Submission No.	286
Organisation Name or Name of Submitter	Suzi Taylor and G.I Taylor

Objection/Observation: Rail Order 2022 (MetroLink-Estuary to Charlemont via Dublin Airport) Case Reference Number NA29N.314724

Client	TII NTA	Project	METROLINK	Drawing Title	METROLINK - STRUCTURES CHARLEMONT STATION PROPOSED STREET LEVEL DESIGN	Drawing Status	S0
Consultant	JACOBS IDOM	Drawing N°	ML1-JAI-SRD-ROUT_XX-DR-Z-02090	Plan Drawing N°	ML-ST 307 O-A1		
		Scales Original Size A1	1:250			Sheet	1 of 6

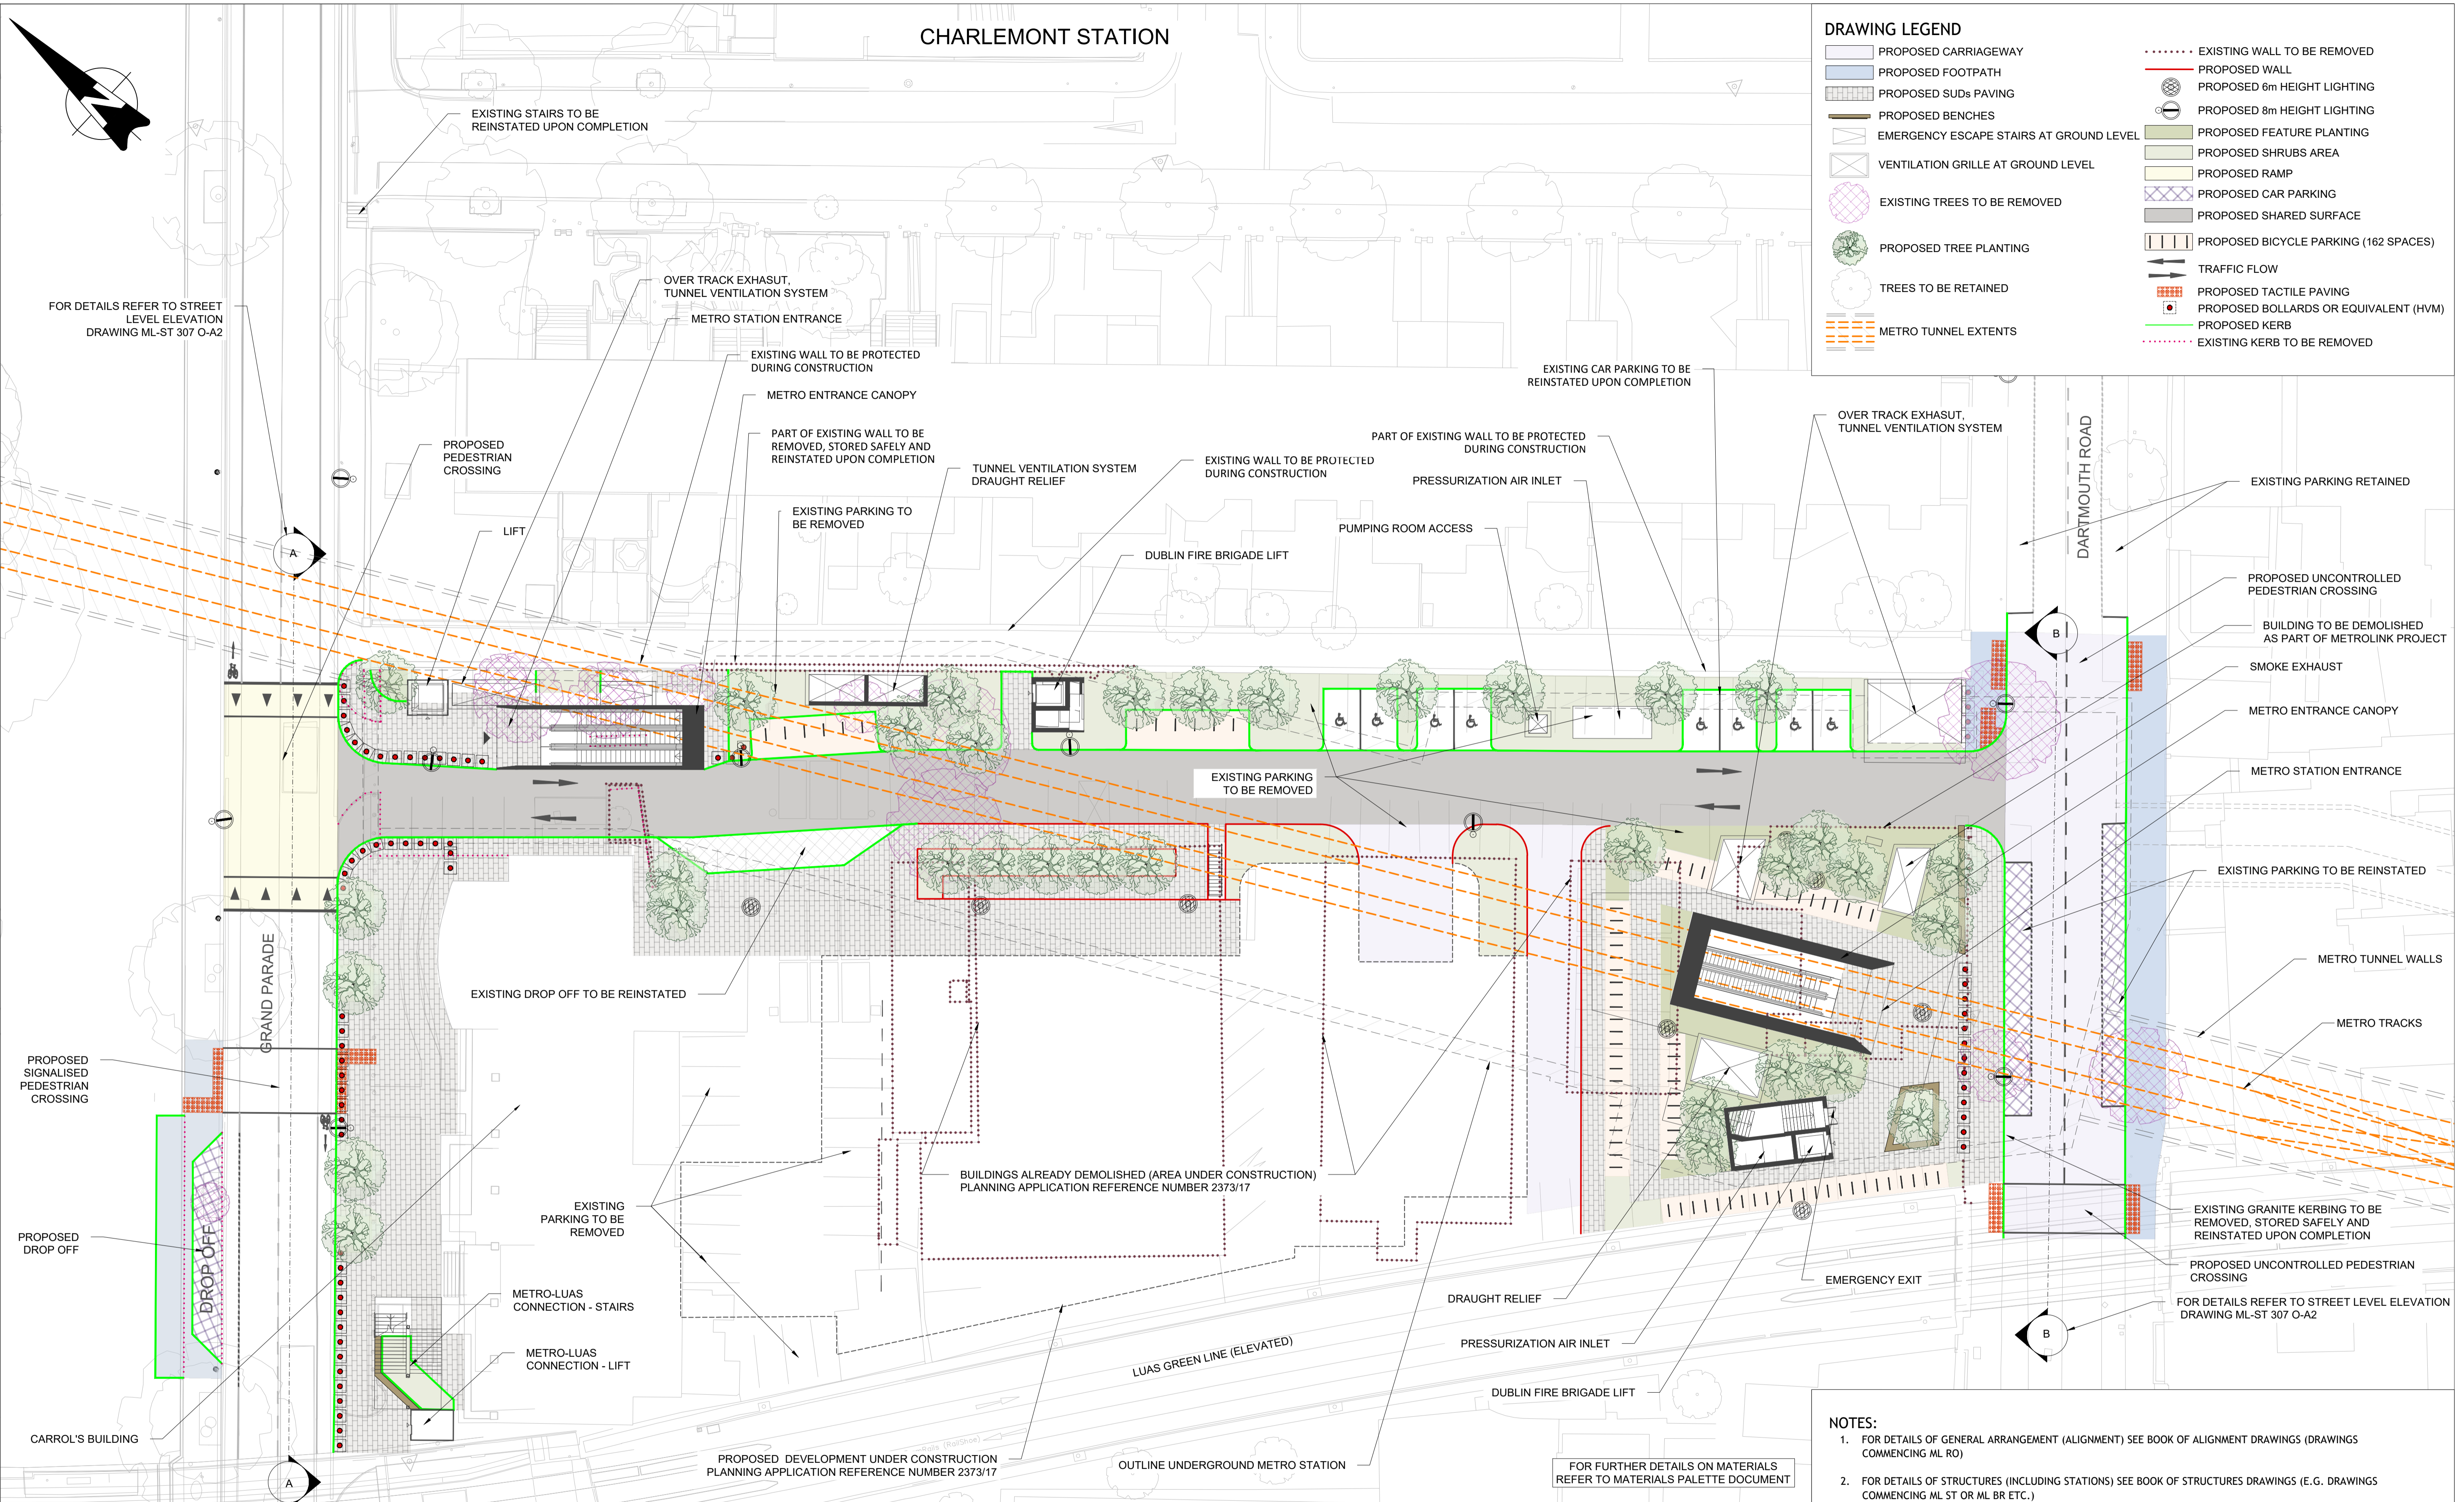
10	Metro station Entrance/Ext on Dartmouth Road	3	<p>The proposed positioning of a Metro entrance/exit right opposite our homes would mean exposing us to continuous extra light and noise, as is usually experienced around station entrances when operational, 365 days/nights annually. The entrance/exit is not suited to a quiet residential road and should not be positioned facing and in such close proximity to our houses. There is no reason why the entrance has to face in this direction, as depicted on plans. Noise would arise from surface passenger movements, with usual luggage, PA announcements, noise of escalators, lifts, rail operating noise, ventilation, local traffic, car parking and set down area, whoever is accessing the station from the south side. There is no indication of screening off entrance area.</p>	<p>The current access arrangement whereby the entrance canopy faces Dartmouth Road is the optimum design solution as it will allow passengers to exit the station and move away from the station quickly.</p> <p>Noise</p> <p>With regards to the noise of operating rail infrastructure, EIAR Chapters 13 and 14 present a comprehensive and detailed assessment of operational airborne and groundborne noise and vibration. No residual noise impacts are identified at this location during operation. The calculated rail noise levels across the proposed Project are not significant in terms of any widespread community disturbance and result in a not significant to slight impact when added to the prevailing noise environment.</p> <p>EIAR Chapter 13, sections 13.2.3.2 and 13.5.3.2.3 recognise that ventilation systems if not designed and mitigated effectively are potential noise sources. Section 13.6.2.3 outlines the detailed considerations that will be included in the design to ensure that the ventilation systems do not exceed limits as per BS 4142, including:</p> <ul style="list-style-type: none"> • Reduction of induct flow rates; • Reduction of elements in the airflow; • In duct attenuators; • Orientation of grilles and louvres away from sensitive receptors; • Acoustic louvres; and • Anti-vibration mountings and couplings will be incorporated into the design to control vibration. <p>Measures to mitigate noise from the use of public address systems is also detailed in Chapter 13 (sections 13.5.3.2.4 and 13.6.2.4). Best practice design principles will be employed to minimise noise breakout at the surface from these systems via escalators, lift shafts and stairwells.</p> <p>Mechanical elements associated with lifts and escalators are housed below ground and are fully enclosed. The operation of lifts and escalators will not generate any notable noise sources during operation and will not be audible above the prevailing noise environment.</p> <p>With regards to stations entrances, these are transient areas for passengers entering and exiting the station. These activities are not the source of significant noise generation and form part of the existing soundscape in the existing prevailing environment. It is acknowledged footfall numbers will increase in the vicinity of the station entrance, however this activity does not translate to significant noise impacts.</p> <p>As noted above TII have deliberately designed the Station with minimum set down space (with the exception of a drop-off on Grand Parade for persons of restricted mobility only) or room for taxi ranks so that it does not encourage the Station to be used as a terminus. There will be no car parking or set-down areas on Dartmouth Road.</p> <p>Finally, the Operator will be required to adhere to noise limits to ensure that there are no significant effects. To provide further assurance, it will also be a requirement placed upon the MetroLink operator to act responsibly and considerately, and be a 'good neighbour' when operating the station.</p>

11	Barriers along pavement outside 32-34 Dartmouth Road	3	The proposed barriers at 6.4 m only reach half way up the upper floor of the houses 32-34, leaving the upper rooms very exposed to the vibration, noise, dust pollution etc and lack of privacy from this operation.	<p>The proposed barrier (hoarding) is 4m high along the east boundary by houses 32 to 34. The primary purpose of the hoarding is to mitigate airborne noise. The height of the barrier has been determined through modelling and calculation of predicted construction noise levels.</p> <p>Refer to Response (6) for Vibration impact assessment.</p> <p>As explained by Response (6) above, an acoustic enclosure will also be provided at Charlemont during night-time support works for sprayed concrete tunnelling works. The full range of noise mitigation and vibration mitigation measures are detailed in Section 6.2 of the CEMP (Appendix 5.1 of the EIAR).</p> <p>Whilst the barriers will provide mitigation for dust emissions, the main control measures will be focused on preventing dust generation and controlling generation at source (see response (6) above). The full range of dust mitigation measures are detailed in Section 6.3 of the CEMP, Appendix A16.2 (Site Specific Potential for Construction Phase Dust Impacts) and Appendix A16.4 (Dust Management Plan) of the EIAR.</p>
